PROJECT NO. PR-2019-002671

Application No. SI-2021-00255 and -00256

Memorandum

Re: DRB Comment Responses for PR-2019-002761 (SI-2021-00255 and SI-2021-00256)

SHEET CONTENTS:  
 CLUBHOUSE ELEVATIONS  
 SHEET NO.  
**A8.02**  
 20213

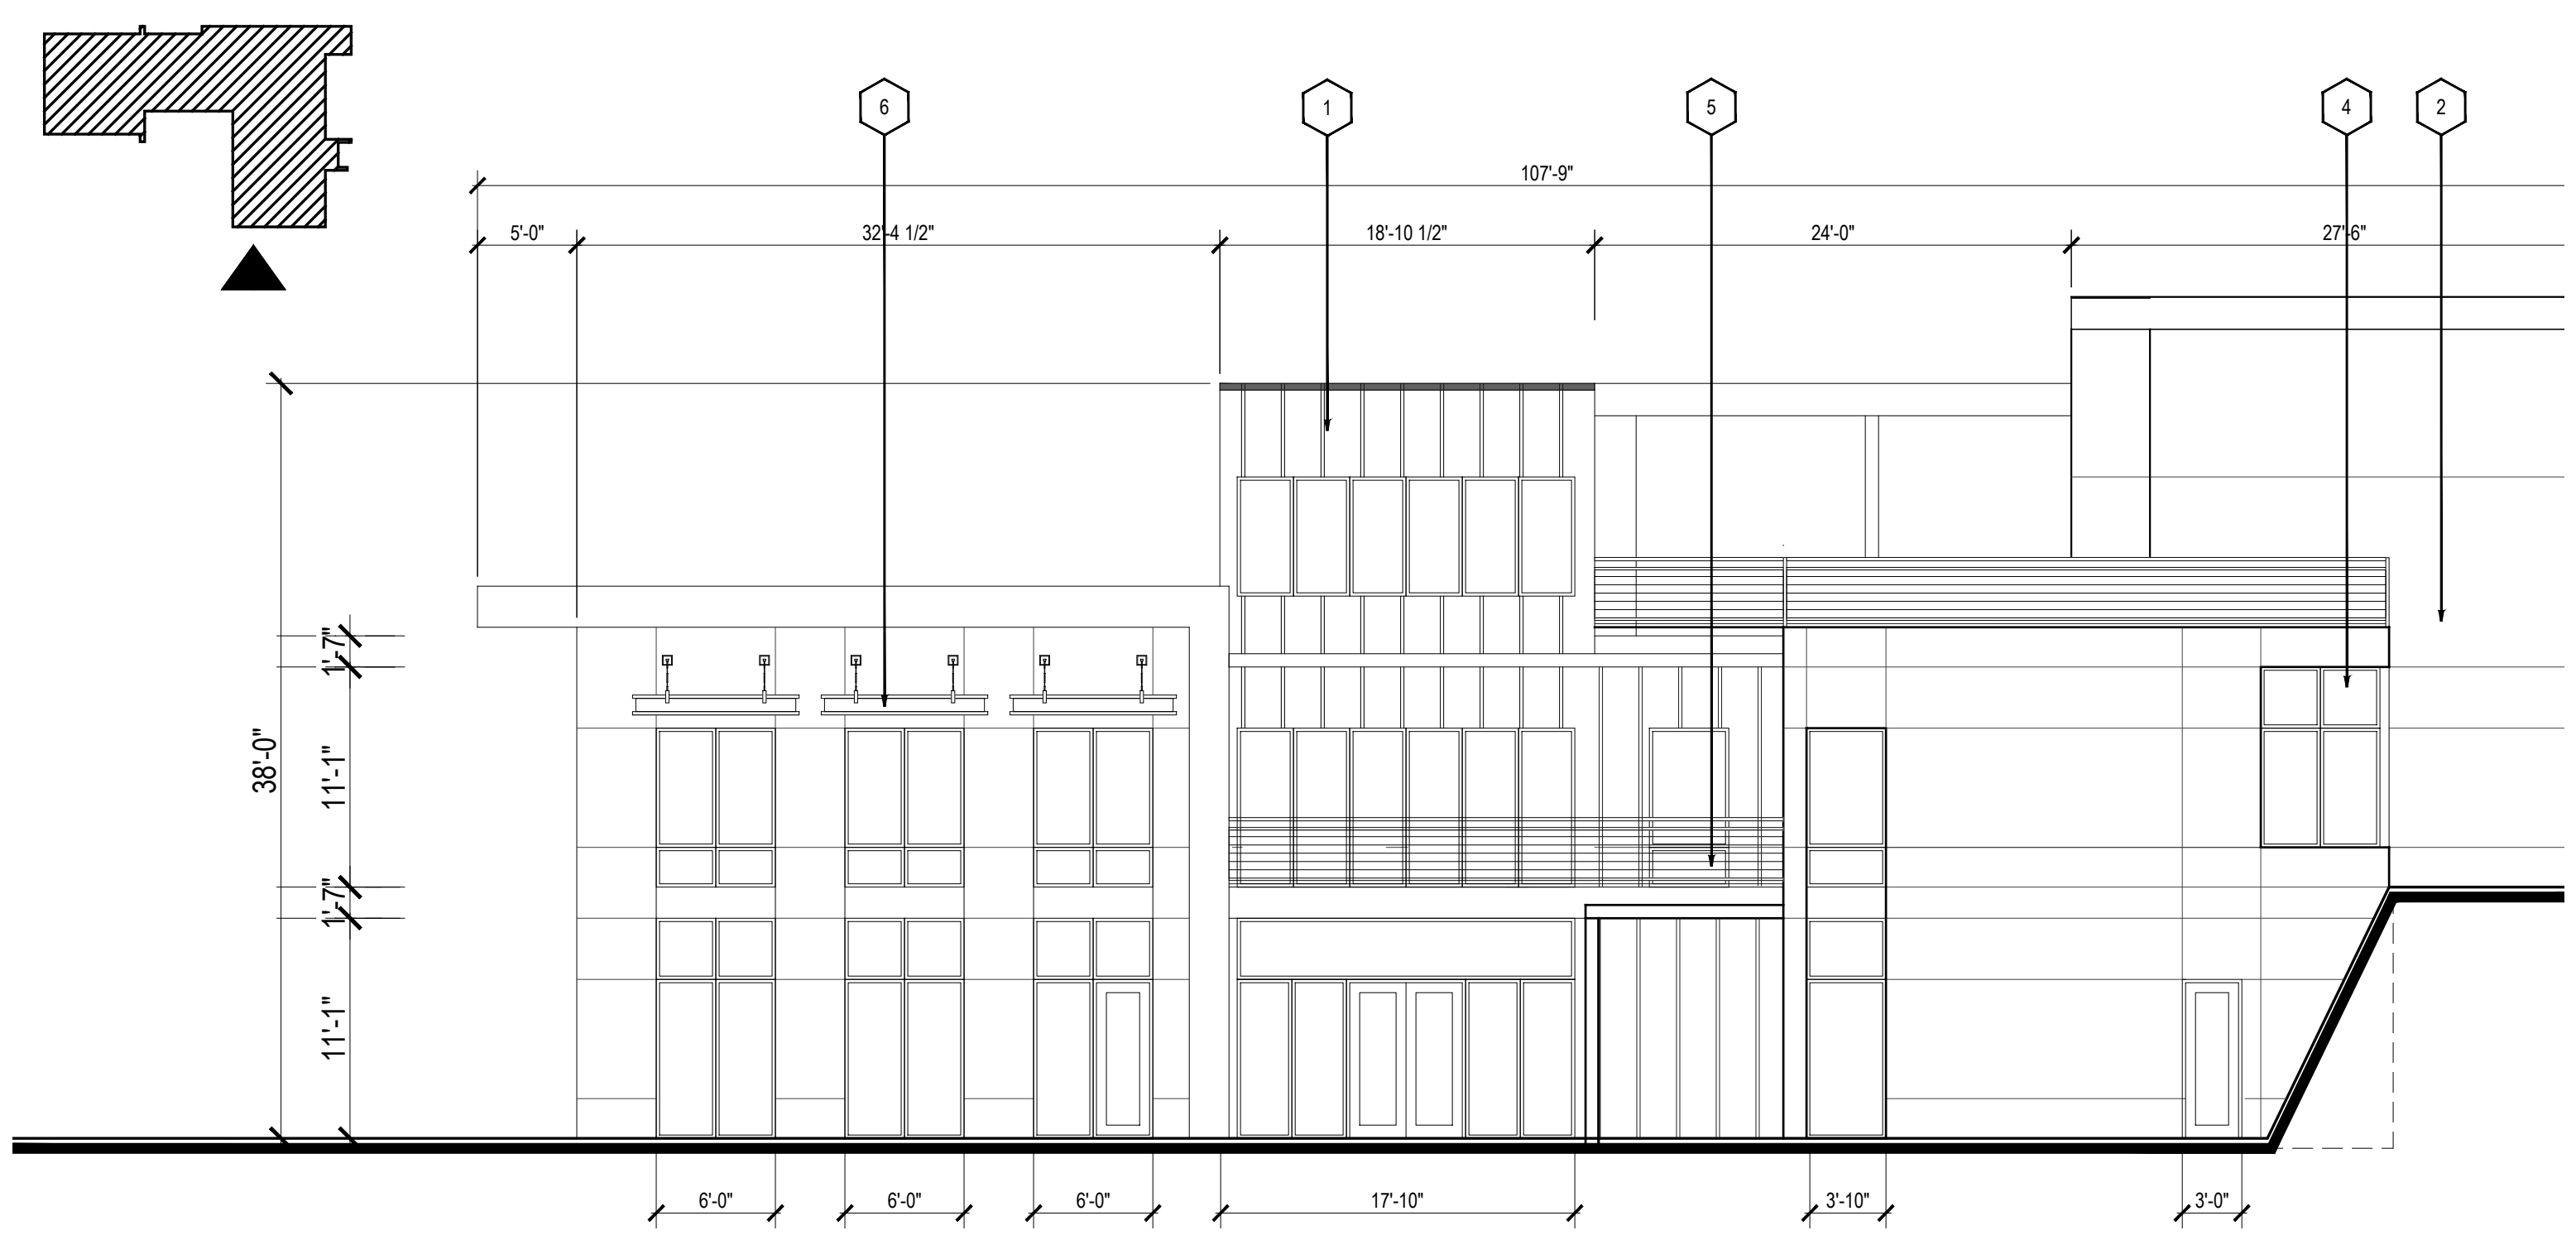
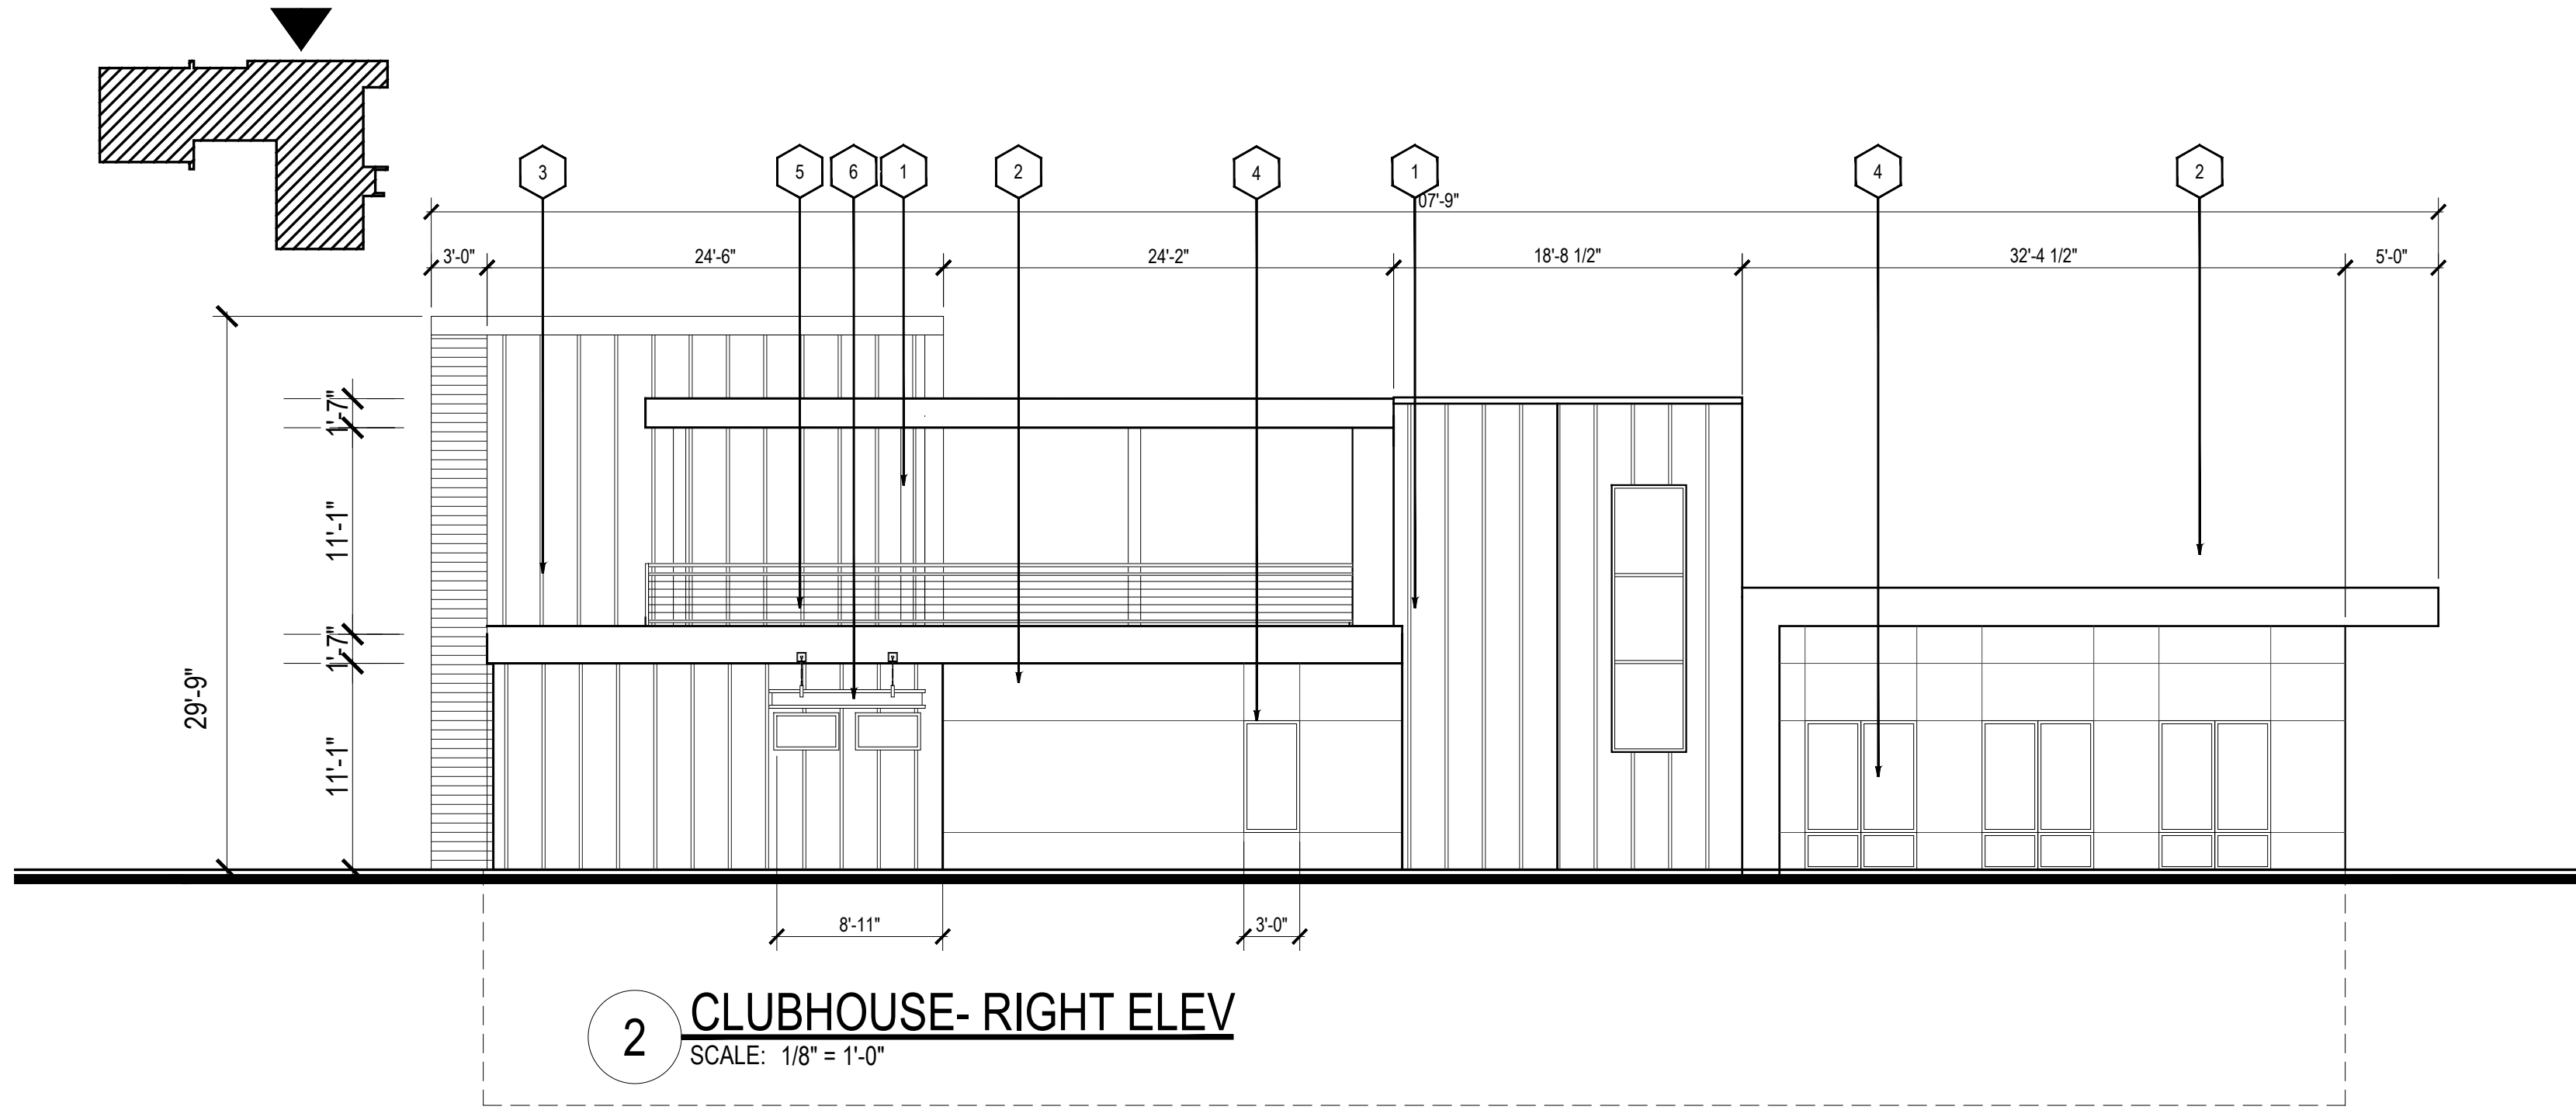
10. Specify how the Façade Design requirements of 5-11(E)(2)(a) are being met in a comment response letter and/or on the Site Plan.
 - a. 5-11(E)(2)(a) regulates building design for street-facing facades. The only facades within the proposed development that are street-facing are the north elevations of Building Type I (left) and the Clubhouse (right).***

The awnings, building overhangs, and horizontal trims around the clubhouse are respective of the human scale and visually indicate separation between ground and upper floor. The north side of the clubhouse building includes several large windows with an overhang on the right side and additional windows in the center of the elevation. An additional transom window with an awning has been added to the left side of the elevation to ensure that at least one required element is

provided at least every 40 feet along the façade. These windows and the awning cover at least 40 linear feet of a total façade length of 106 feet or approximately 38%. Because this façade is over 100 feet long, there are variations in the façade, including projections and recesses as well as multiple colors to break up the mass.
